Location of Construction: 63 MURRAY STREET		Owner: LEE DIPIASE		Phone: 831-3099		Permit No: 001365
Owner Address: SAA		Lessee/Buyer's Name:		BusinessName:		
Contractor Name: *** LEM BUILDERS *** 151 GRAY RD FALMOUTH ME 797-7089		Address:		Phone:		Permit Issued: NOV 30 2000 162-D-033
Past Use: VACANT		Proposed Use: NEW SINGLE FAMILY		COST OF WORK: \$ 0		
Proposed Project Description: AMEND 001314 MOVING LOCATION OF HOUSE		Signature:		PERMIT FEE: \$ 30.00		Zone: CBL: 162-D-033
				INSPECTION: Use Group A-3 Type 5B , 00CA 99		
Signature:		Date:		PEDESTRIAN ACTIVITIES DISTRICT (P.A.D.)		Zoning Approval: 162-D-033 Special Zone or Reviews: <input type="checkbox"/> Shoreland <input type="checkbox"/> Wetland <input type="checkbox"/> Flood Zone <input type="checkbox"/> Subdivision <input type="checkbox"/> Site Plan maj <input type="checkbox"/> minor <input type="checkbox"/> mm
				Action: Approved <input type="checkbox"/> Approved with Conditions: <input type="checkbox"/> Denied <input type="checkbox"/>

TO: Inspections
FROM: Jay Reynolds, Development Review Coordinator
DATE: August 17, 2001
RE: C. of O. for # 63 Murray Street (CBL 162-D-033) (ID 2000-0205)

Project description:
Build 8x10 Deck

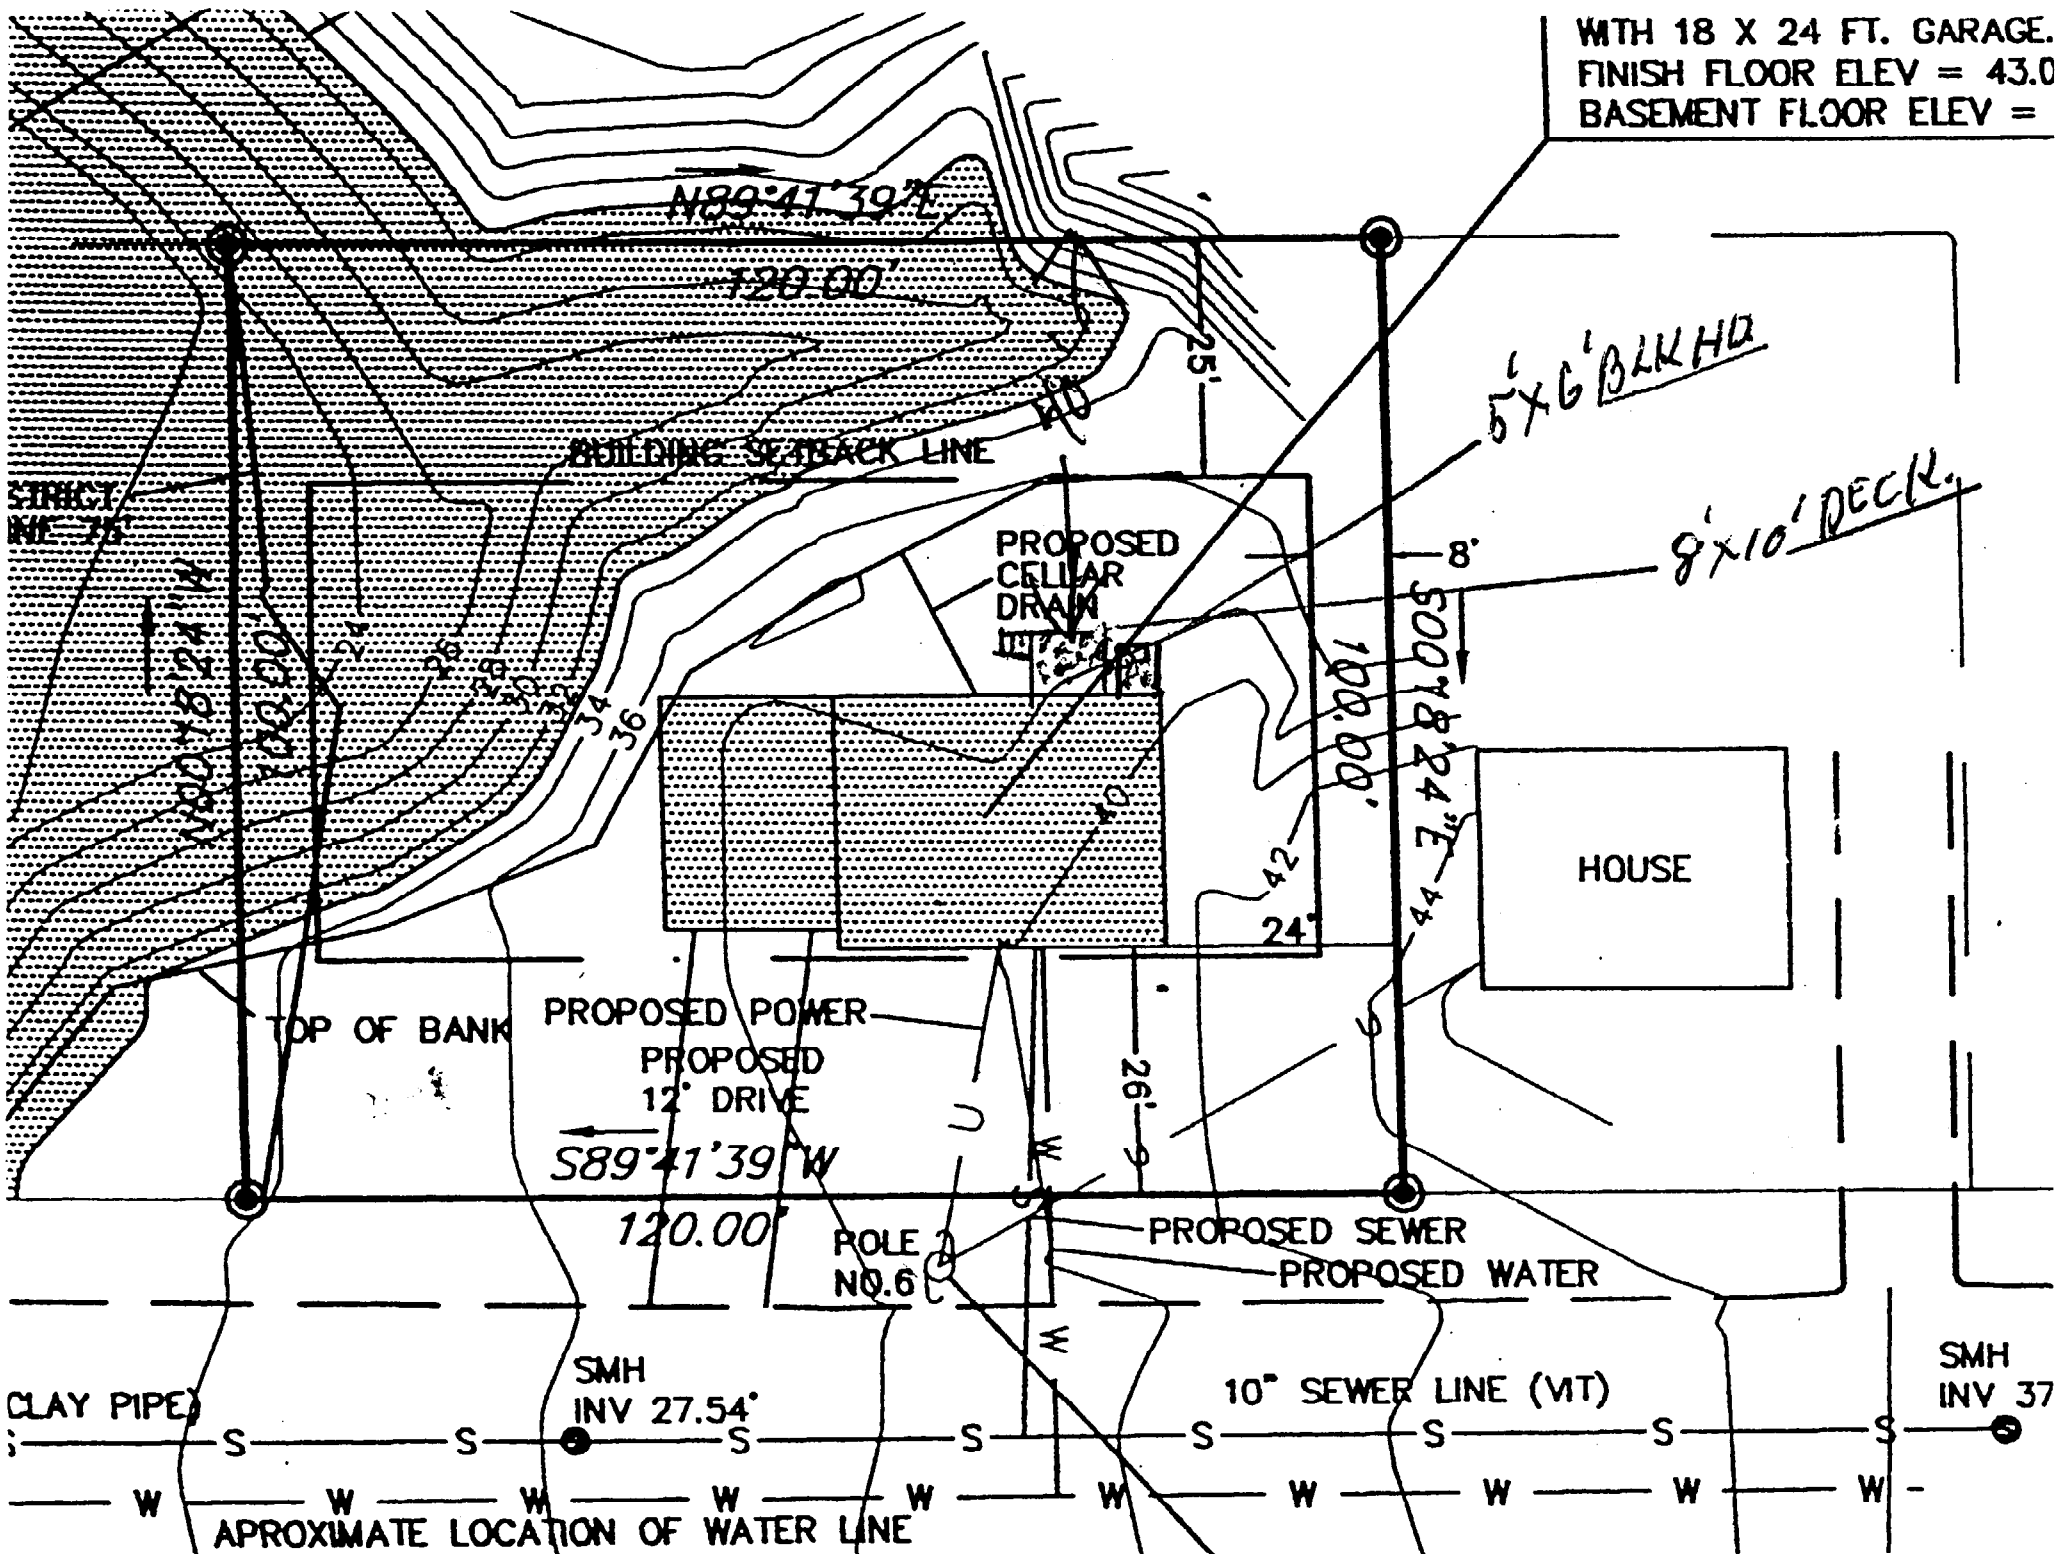
7/19/01 Final inspection - Deck on rear needs permit - Amendment. Deck needs Joist
Hangers & bolt fasten to structure - Footing appear to be set w/ post anchored. Steps measure
OK - need graspable handrail w/ return. No water on ~~deck~~ Fixtures not all installed
Scuttle is only 17" x 17 1/2". Bulkhead not shown on plans - Amend
